From: Liz Annalls [REDACTED]
Sent: 15 January 2020 10:50
To: Planning.Responses <Planning.Responses@arun.gov.uk>
Subject: RE: Planning Consultation on AL/106/19/DOC

App No: AL/106/19/DOC

Address: Nyton Nursery Nyton Road Westergate PO20 3UQ

Proposal: Approval of details reserved by condition imposed under ref AL/3/19/PL relating to Condition Nos 5 - soft landscaping plan & landscape and ecology management plan; 7 - external lighting; 10 - Construction Management Plan; 13 - employment and skills plan; 14 - broadband provision; 15 - electric vehicle charging strategy; 16 - renewable energy; 19 - surface water drainage; 20 - discharge flows and 21 - surface water drainage maintenance and management

REV. No.	DATE	DESCRIPTION	INITIALS
Client			
Project	Westergate & Eastergate		
Title	External Works Layout Sheet 1	Scale 1:250@A0 Checked AMc	Date Mar '18 Drawn KT
Drawing No.	5655:40	Rev	H

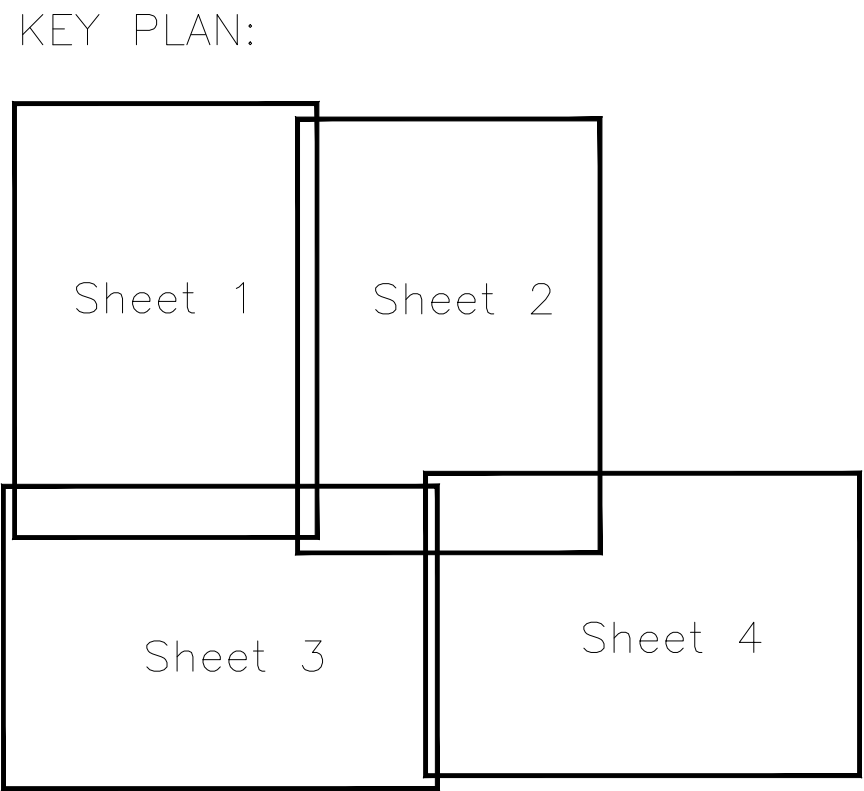
Though some information on external street lighting has been provided within the engineer drawings we require further information on the external lighting which will be installed on the units onsite, avoiding unnecessary artificial light spill to hedgerows and buildings through the use of directional light sources and shielding.
